**WELWYN HATFIELD BOROUGH COUNCIL
EXECUTIVE DIRECTOR - PLANNING, PUBLIC PROTECTION AND GOVERNANCE**

DELEGATED APPLICATION

Application No: 6/2018/0291/HOUSE
Location: 44 The Ridgeway Cuffley Potters Bar EN6 4BA
Proposal: Erection of a double storey side and single storey rear extension, front porch with access, driveway and frontage alterations
Officer: Mr William Myers

Recommendation: Refused

Rev:	Details:	Date:
Project:	Drawn By:	
44 The Ridgeway	SOM	
Cuffley	Date Drawn:	
EN6 4BA	14/12/2017	
Drawing Title:	Drawing Number:	
PROPOSED FRONT & SIDE ELEVATIONS A1	TDC027/PL/205	
Scale:	Rev:	
1:50	-

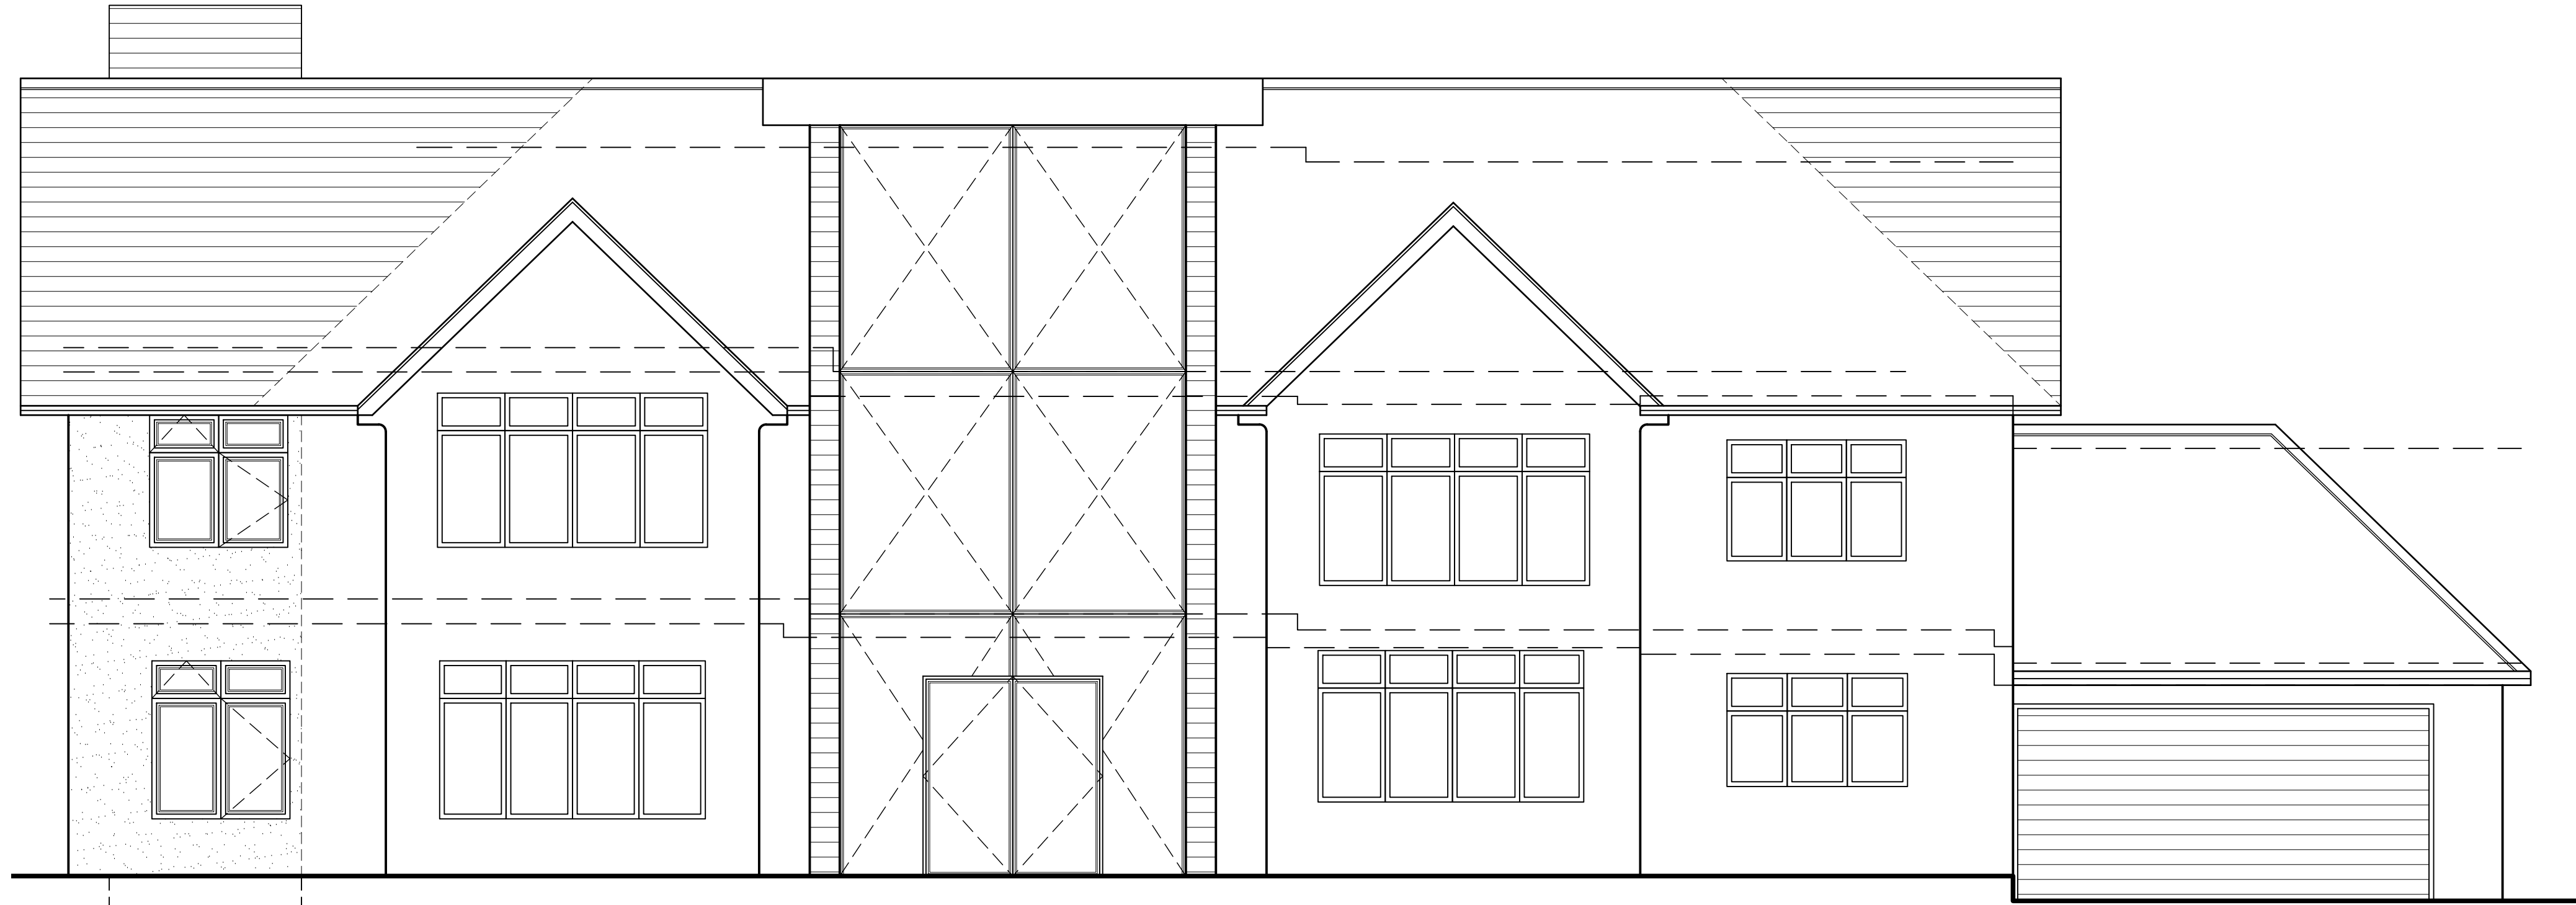
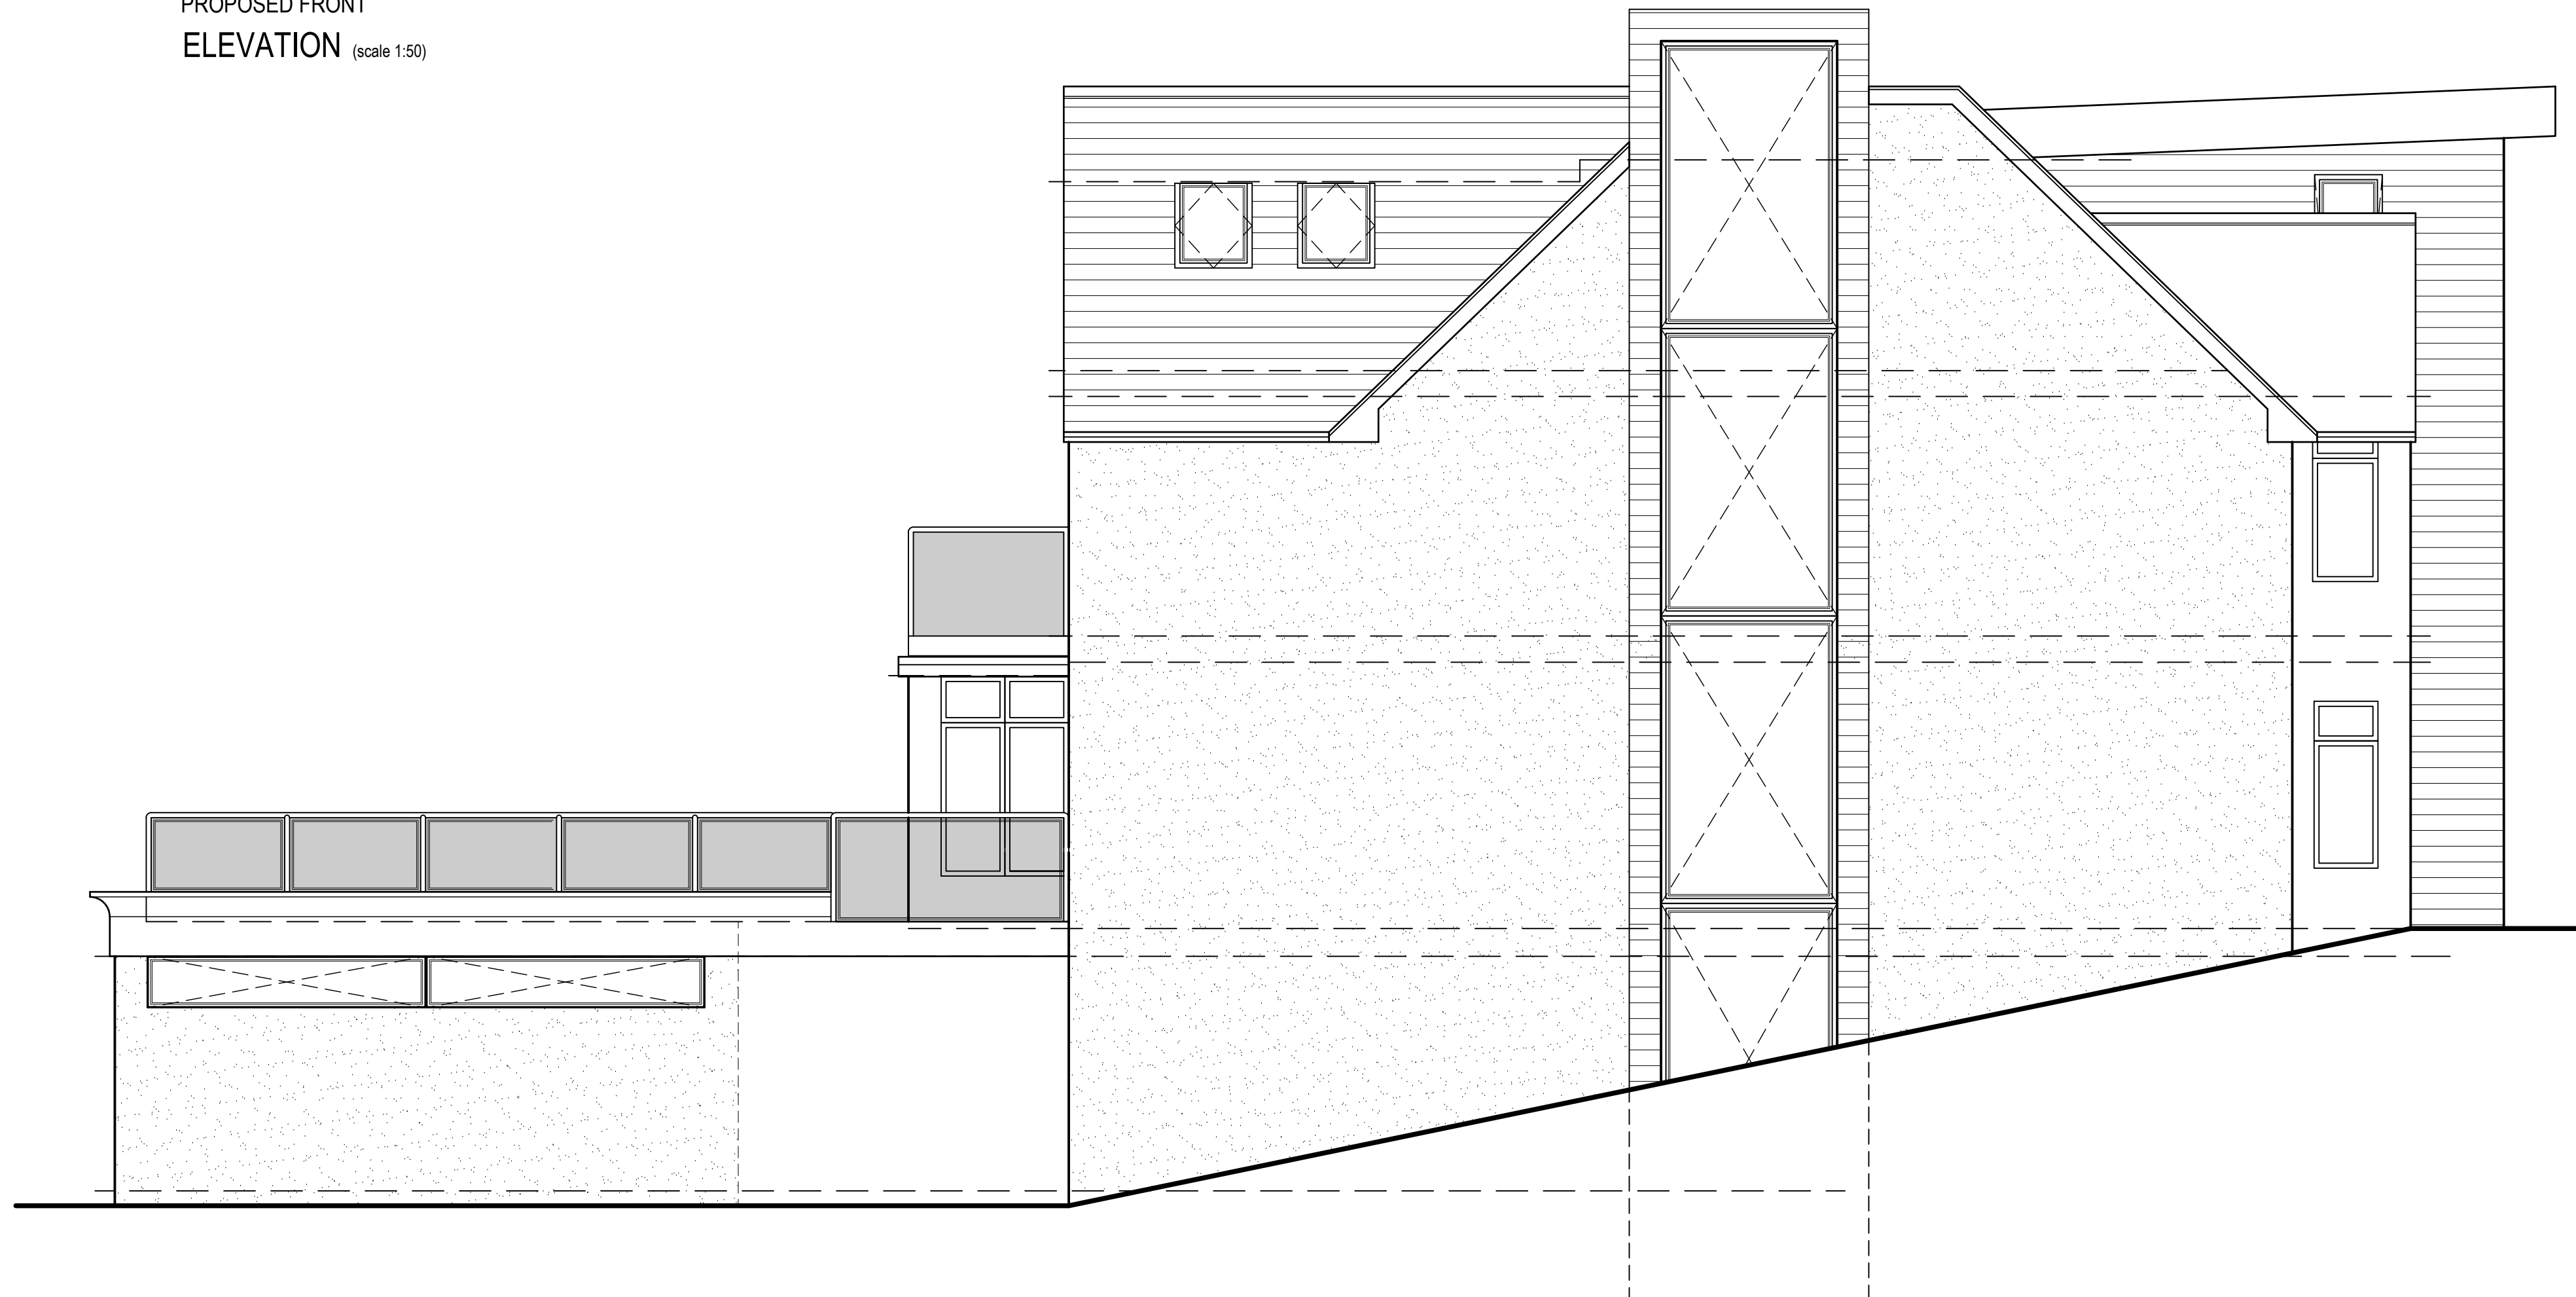
- A two storey side extension, a single storey rear extension;
- the creation of a two storey porch to the front of the property which would have a flat roof which would be effectively equal in height to the ridge line of the existing dwelling;
- the changing of the current hipped roofs on both side elevations of the dwelling to gable ends;
- The increasing of the roof height on the existing larger rear projection so that it is level with the ridge line of the main roof and no longer set down by approximate 0.4m; and
- The increasing of the width of the existing larger rear projection by approximately 2.5m.

<p>Design (form, size, scale, siting) and Character (appearance within the streetscene)</p>	<p>Local Plan Policies D1 and D2 aim to ensure a high quality of design and to ensure that development respects and relates to the character and context of the locality, maintaining and where possible enhancing the character of the existing area. These policies are expanded upon in the Council's Supplementary Design Guidance (SDG) which requires the impact of a development to be assessed giving regard to the bulk, scale and design of the proposal and how it harmonises with the existing building and area. These objectives are broadly consistent with a core principle of the NPPF which states that good design is a key aspect of sustainable development, is indivisible from good planning, and should contribute positively to making places better for people.</p> <p>At the front of the property it is proposed that a large two storey porch would be constructed, which would effectively be the same height as the ridge of the main roof of the dwelling and would project approximately 2.1m, with a width of approximately 4.3m. Its front elevation would be almost completely glazed and it would project further than the existing front projects by approximately 1m. The porch would be clad with timber and not render as currently existing on the front elevation of the property. Instead of having a pitched roof which would be more sympathetic to the main roof of the dwelling or the existing front projections, it is proposed that it would have a flat roof which would slope slightly from its front to the existing dwelling. It is considered that the proposed fenestration within the porch and the use of timber would not complement or reflect the design of the existing dwelling. This is because the proposed fenestration would introduce a pattern that would be alien to the existing fenestration pattern within the front elevation and the timber would poorly relate to the white render used in the rest of the front elevation. Overall, the impression is of additions which have been designed with the intention of standing out from the existing building and to make a bold contemporary statement. In doing so the extensions would dominate the existing building and pay scant regard to its form, proportions and characteristics.</p> <p>The two storey side extension that is proposed on the eastern elevation of the dwelling would project approximately 2.5m from the existing side elevation,</p>

<p>with its front elevation being flush with the existing front elevation of the dwelling and its rear elevation being in line with the existing rear projection on this side of the dwelling. It is proposed that the main roof would also be extended over the extension and its roof form would be changed from a hipped roof to a gable end. This change in roof form would be mirrored on the other side of the dwelling. The change to the roof on the eastern elevation would also result in the creation visible crown roof within this elevation. To the rear the proposal would result in the existing rear projection, on this side of the dwelling, being increased in width by 2.5m and its roof being increased in height and changed from a normal gable end roof form to a gable end with a pronounced, and visible crown roof, which would be approximately 1.9m in width. The lift shaft would be located within the side extension, with the submitted drawings illustrating that the top of the lift shaft would project above the ridge line of the existing, and proposed roof, by approximately 0.75m. When viewed from the eastern and rear elevations, the proposed works on these elevations would appear awkward and poorly designed. In addition, timber clad lift housing would be a prominent feature, which would not complement or relate to the existing building because of the size of the projection above the roof line and the choice materials which would be unsympathetic. Consequently, these features would be poorly composed, creating the impression of an incongruous and un-coordinated extension which would poorly relate to the existing dwelling.</p> <p>The single storey rear extension would result in the replacement of an existing conservatory which projects approximately 3.3m and is approximately 5.8m in width, with an extension that would project approximately 6.3m and be 8.8m in width. In addition, it is proposed that the roof of this rear extension would create a raise platform/terrace with an approximate area of 69m². It is considered that even though the application property is a large dwelling the extension would still amount to a significant addition to the existing dwelling which would not complement or reflect the design or character of the existing dwelling.</p> <p>It is noted that the applicant proposes to use of matching materials in all the extensions, apart from the porch and lift shaft, which would be acceptable. In addition, it is considered that although the proposed fenestration in the rear of the property would be altered with the use of more glazing than at present and the use of a more contemporary glazing pattern that these aspect of the proposal would be acceptable. Although there are no issues relating to these aspects of the proposal, these slight benefits does not overcome the harm identified above.</p> <p>Overall the proposed development would be excessive in size and would represent a poor standard of design with the result that it is contrary to the NPPF and Policies D1 and D2 of the District Plan which attach great importance to the design of the built environment and the SDG which seeks a design led approach to development.</p>

2. The proposed extensions would be of a poor quality of design and they would insufficiently reflect the design and character of the host dwelling. In addition, the extensions would not be subordinate or subservient to the existing building and would be excessive in size. Accordingly, the proposal is contrary to the National Planning Policy Framework 2012, Policies D1 and D2 of the Welwyn Hatfield District Plan 2005 and the Supplementary Design Guidance 2005.
